**HISTORIC PRESERVATION BOARD  
CITY OF PORTLAND, MAINE**

**PUBLIC HEARING  
414 FORE STREET**

**TO:** Chair Romano and Members of the Historic Preservation Board  
**FROM:** Deb Andrews, Historic Preservation Program Manager  
**DATE:** April 25, 2013  
**RE:** May 1, 2013 Public Hearing

**Application For:** Certificate of Appropriateness for Exterior Alterations and Rooftop Mechanicals  
**Address:** 414 Fore Street  
(corner of Fore and Dana, with frontage on Wharf)  
**Applicant:** Gould Company LLC.  
**Architect:** Richard Borrelli, Harriman Associates

A2 NORTH ELEVATION  
SCALE: 1/8" = 1'-0"

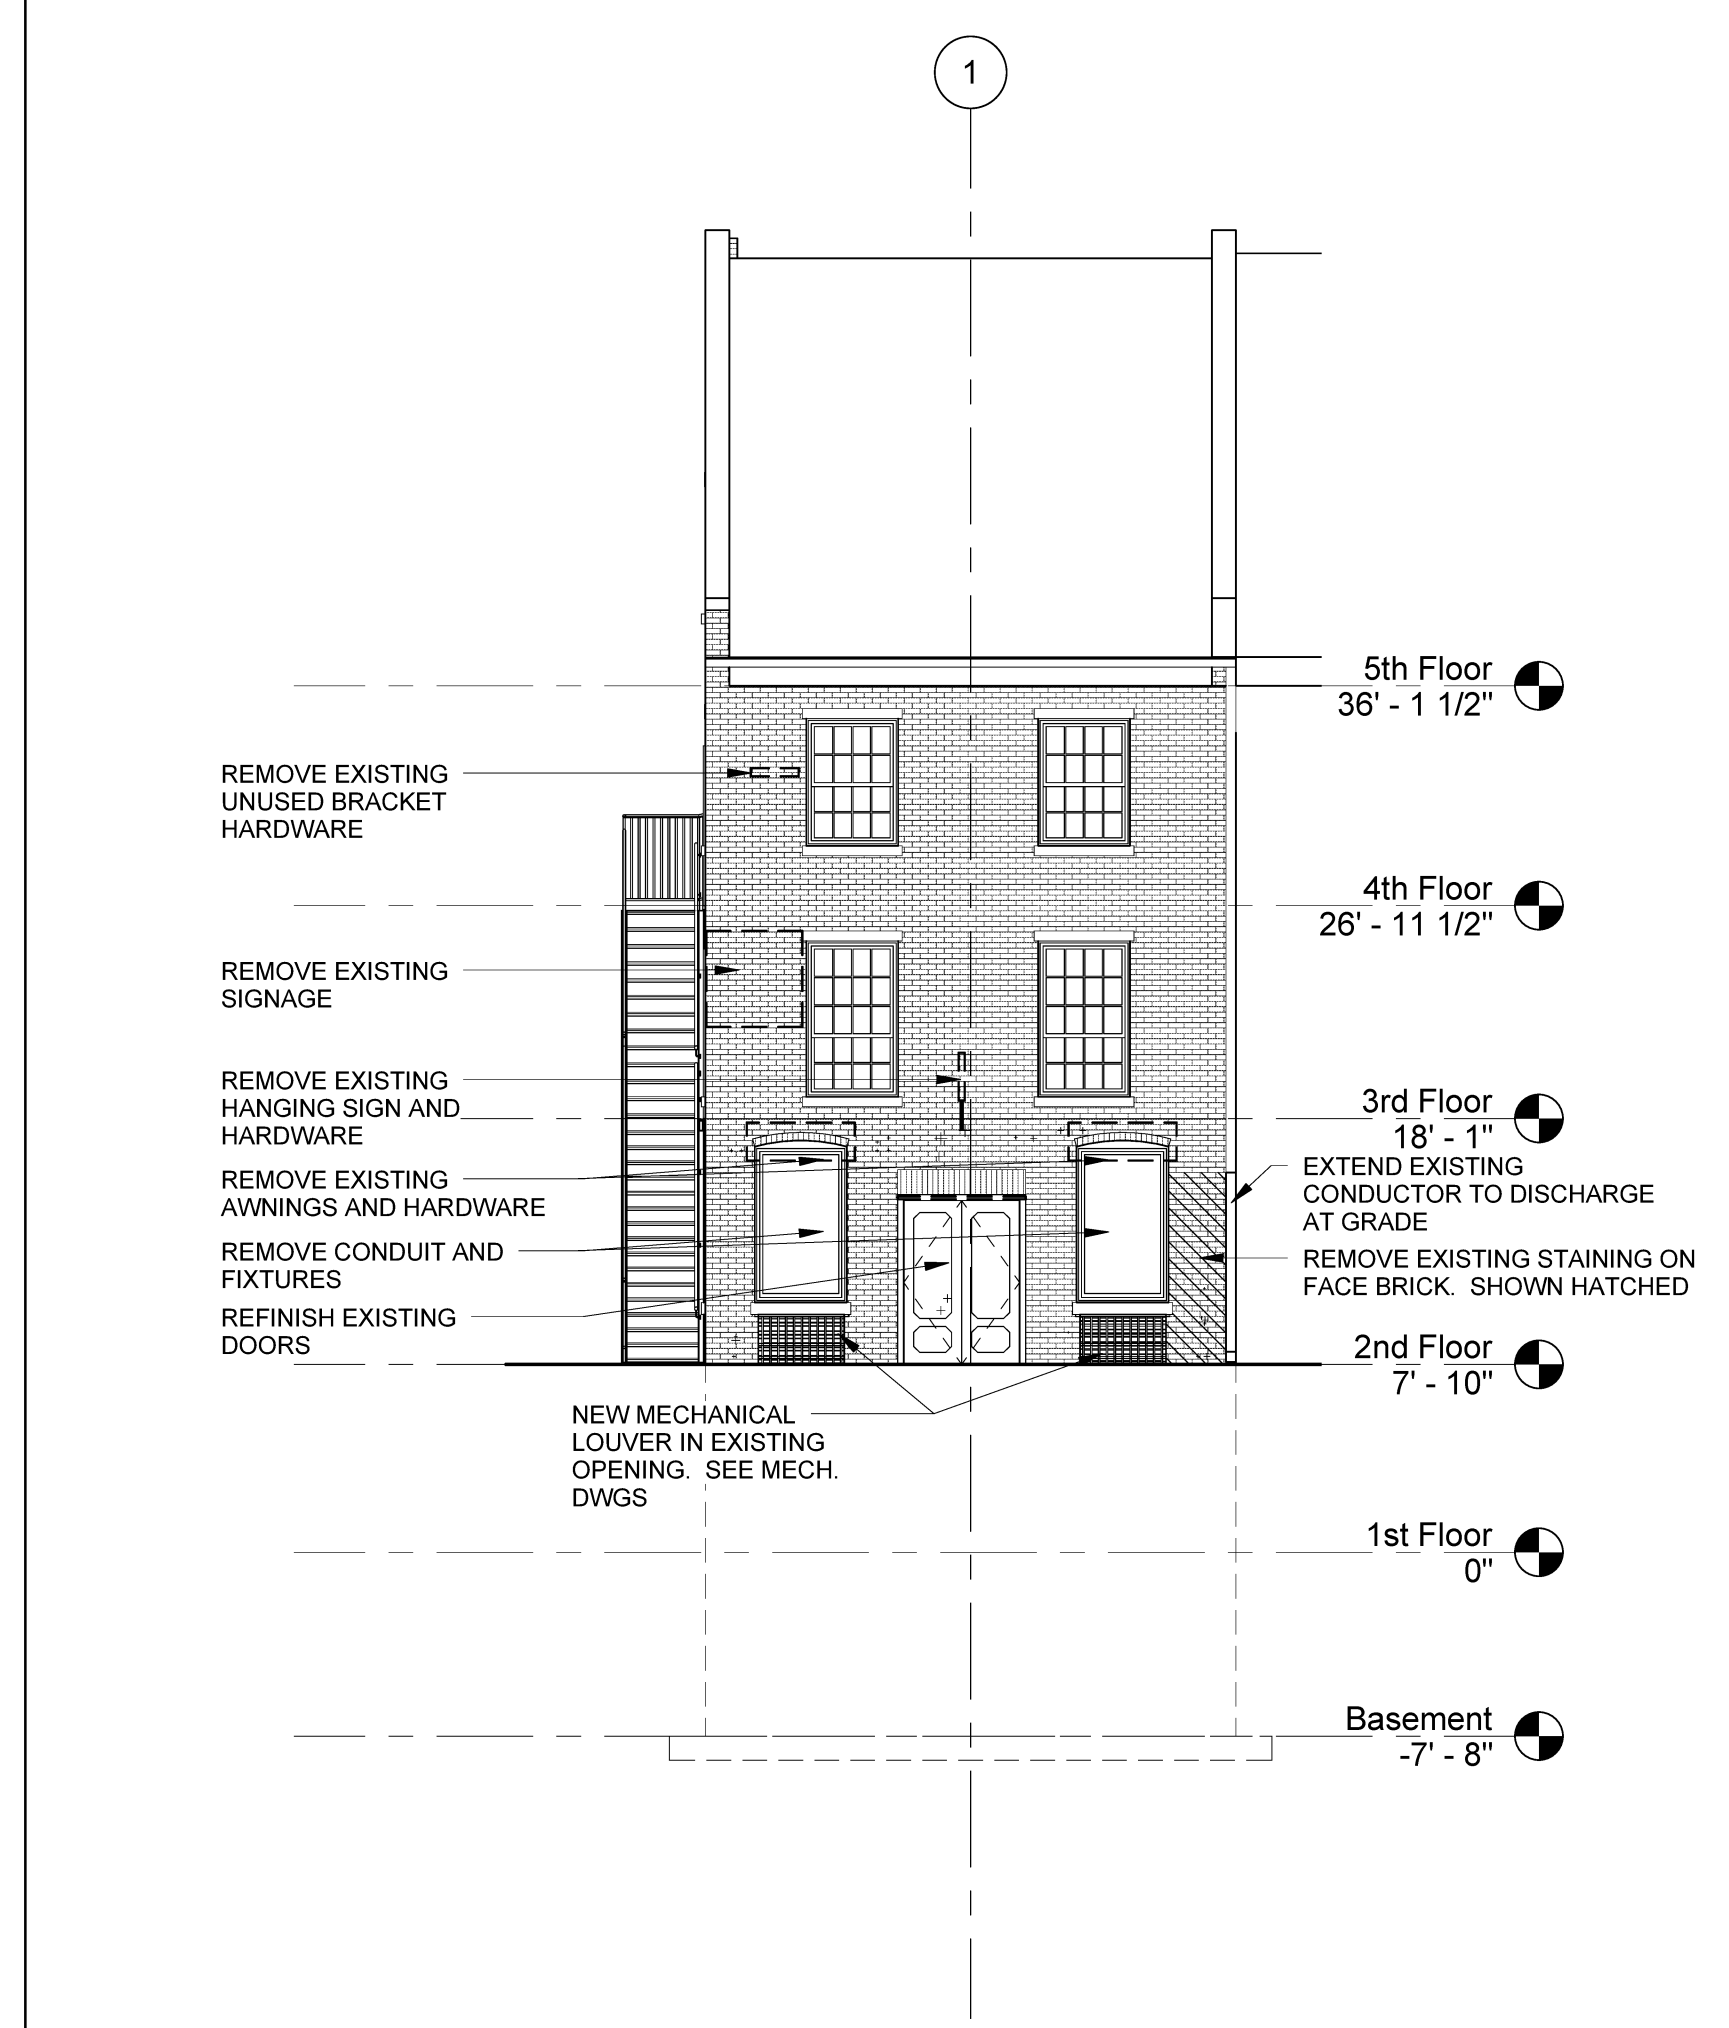
More significant alterations are proposed for the Wharf Street roof plane. Here, two condensers and an exhaust fan are proposed to be installed in a vertical alignment close to the eastern edge parapet wall. To help obscure the mechanical equipment from some vantage points, a metal screen is proposed.

Staff applauds the applicant's intention to clean up the building and remove some of the small accretions that have undermined its architectural clarity. The building certainly warrants this attention. It is somewhat unfortunate, then, that the proposed new use will necessitate fairly substantial changes to the roof, particularly since it is one of the few roof planes facing Wharf Street that does not currently feature various rooftop additions. Mr. Borelli is mindful of the high degree of visibility of this roof plane and has worked to organize and minimize the impact of these rooftop units. The role of the Board is to determine whether the proposed scheme is successful in this regard.

considered as well. Unfortunately, this building offers little opportunity to hide mechanicals, as it is fully exposed on three sides. It would seem that the Board's role in this instance is to ensure that all opportunities for minimizing the equipment's visual impact have been fully explored. In staff's view, factors for consideration should not include the applicant's possible future interest in adding a rooftop deck.
